23 April 2020

Re: Proposed Site Remediation
Interim Audit Advice No. 1 – 8-12 University Avenue, Macquarie Park NSW

This Interim Audit Advice has been prepared to determine the appropriateness of the remediation action plan.

Title:		SAMPLE LOCATION PLAN	
Location:		8-12 UNIVERSITY AVENUE MACQUARIE PARK, NSW	
Report No:		E29775PL	Figure No: 2
JK ENVIRONMENTS

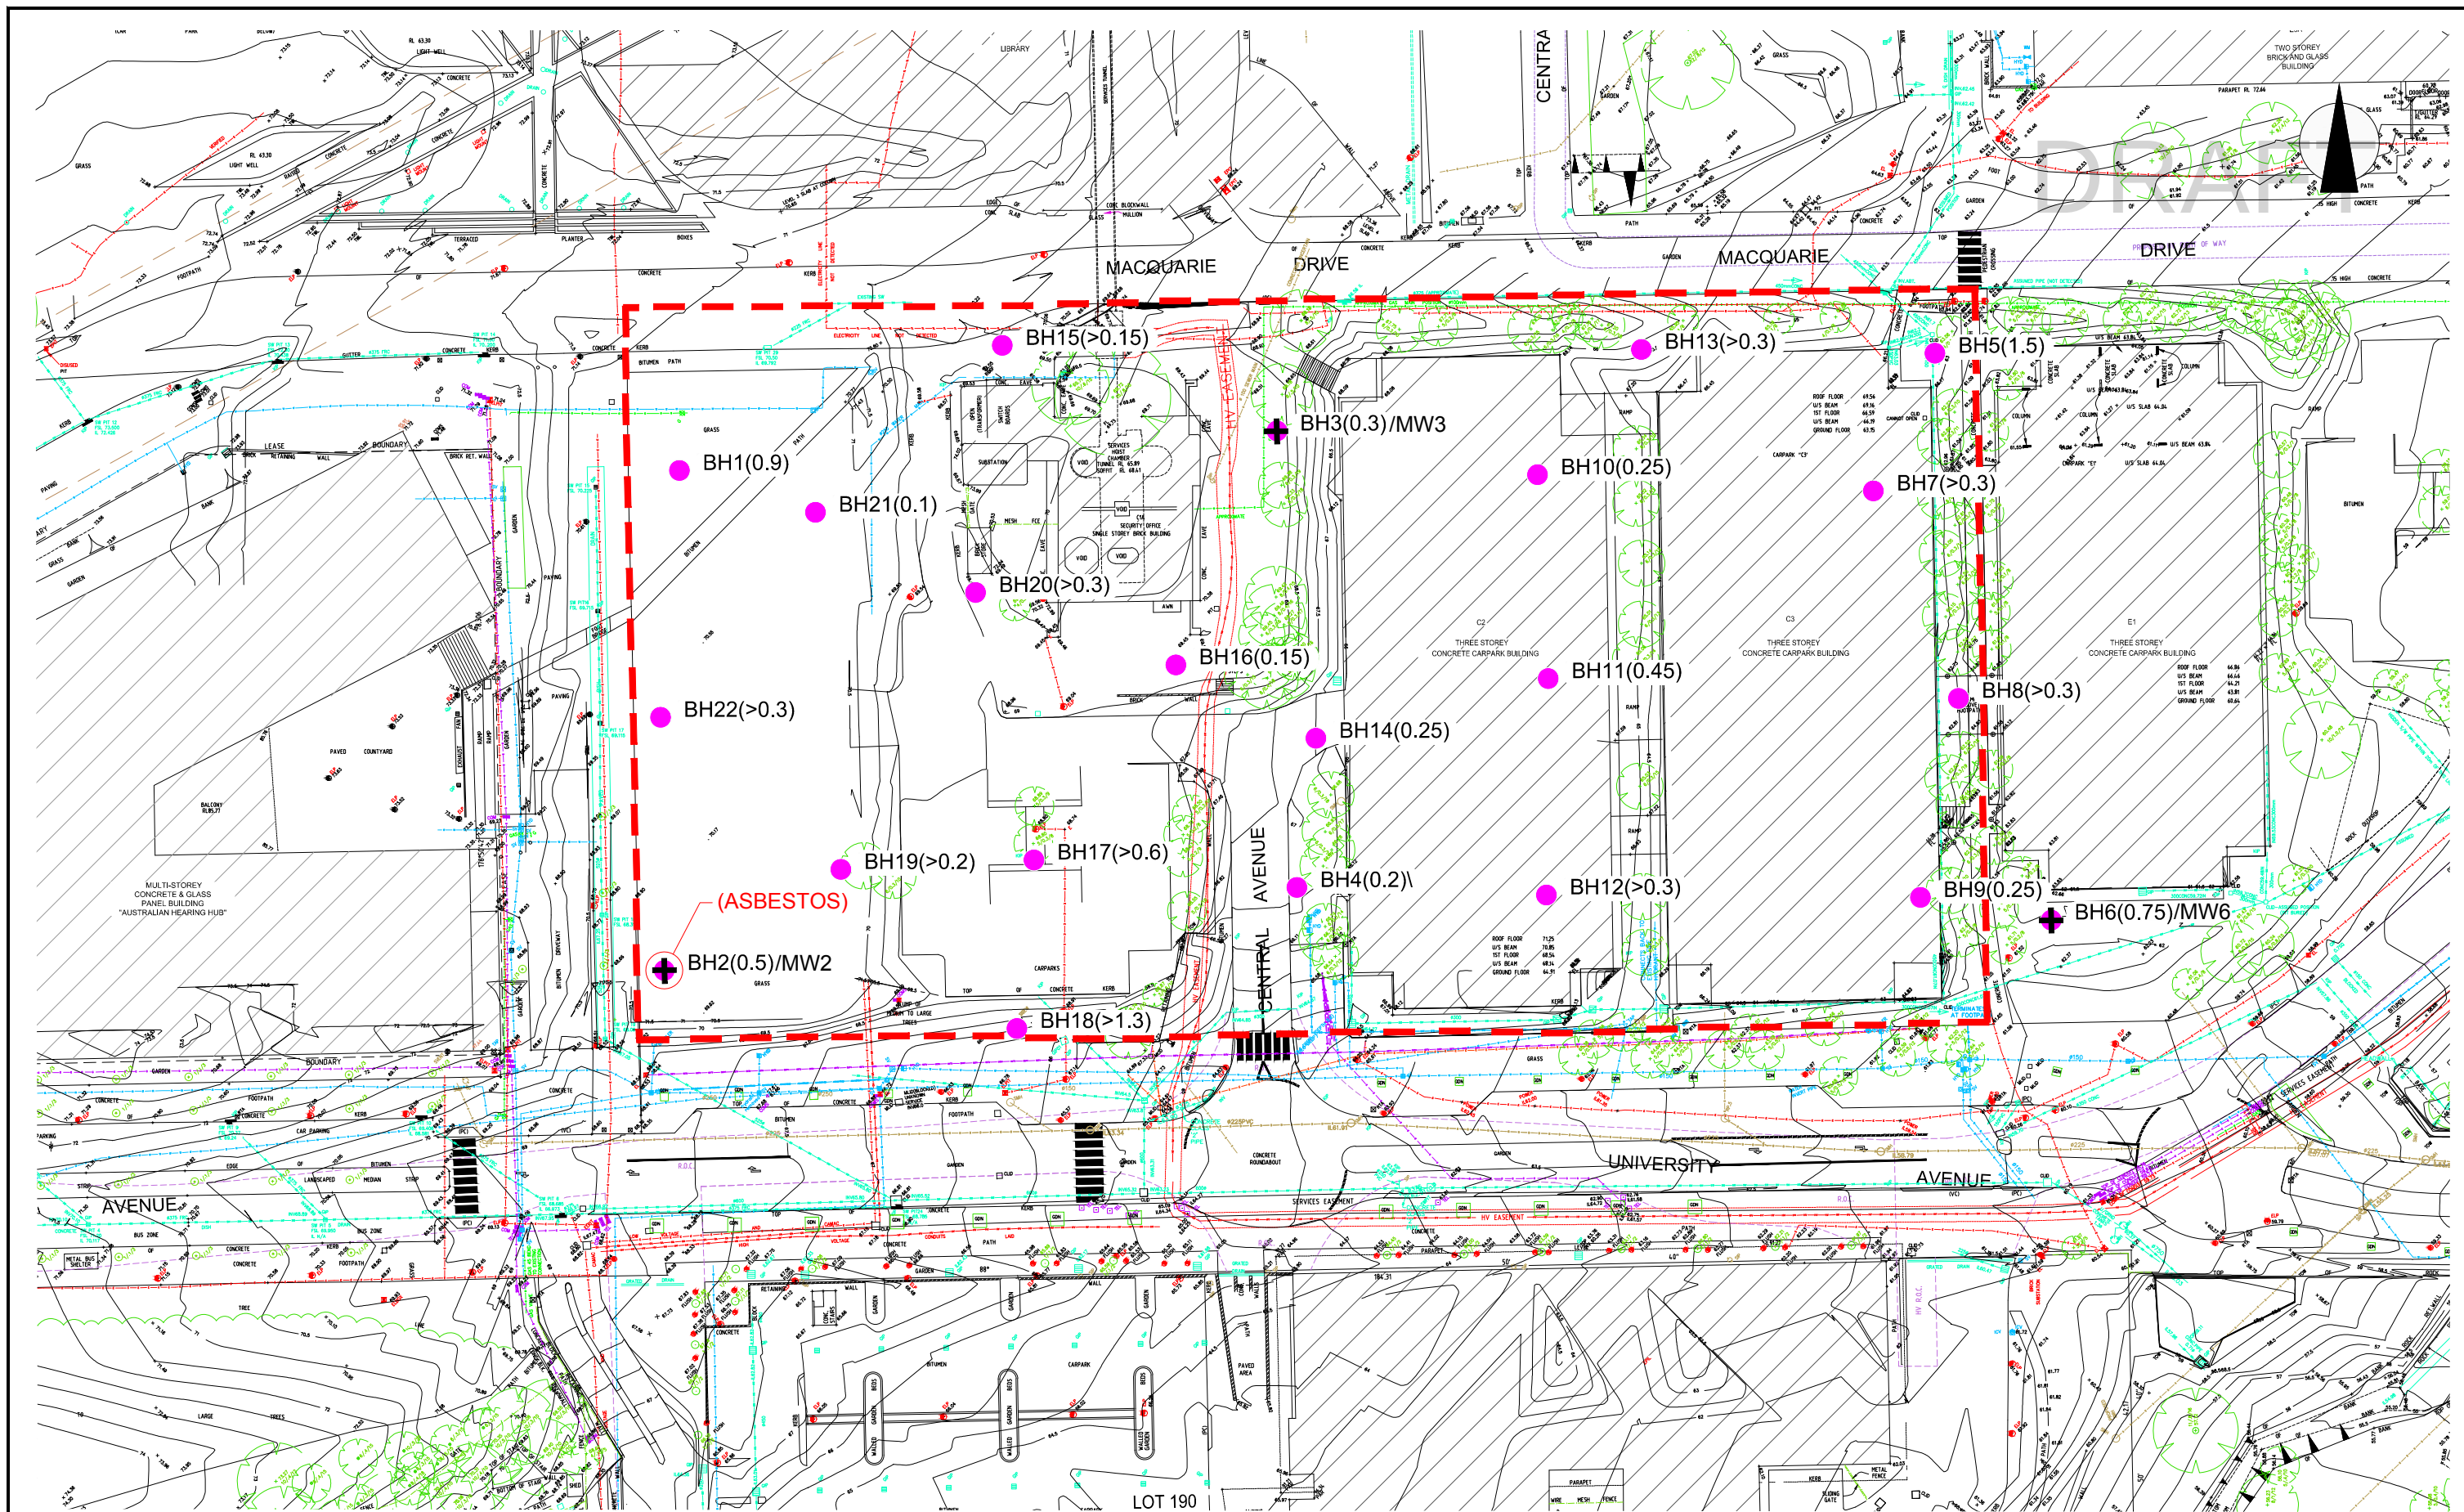
- Section 2.2 Table 2-2. Please state area of the site as is shown by the site boundary in the figures.
- Section 7.2. Table 7-2. Excavation at AEC1 should continue to natural soil.
- Section 8.1.
 - Validation documentation for AEC1 should also include survey plans of the area prior to excavation, following excavation and then at final levels.
 - If possible, VENM should be inspected at the source site by the environmental consultant as well as the receiving site.
 - Please update all asbestos analysis to state 500ml NEPM 2013.
- Section 9.1. Provide an unexpected finds flow chart.
- The RAP will be required to be updated following the data gap assessments. In particular, there is currently no discussion around the remediation requirements for the electrical substation. This is will need to be included in an updated RAP.
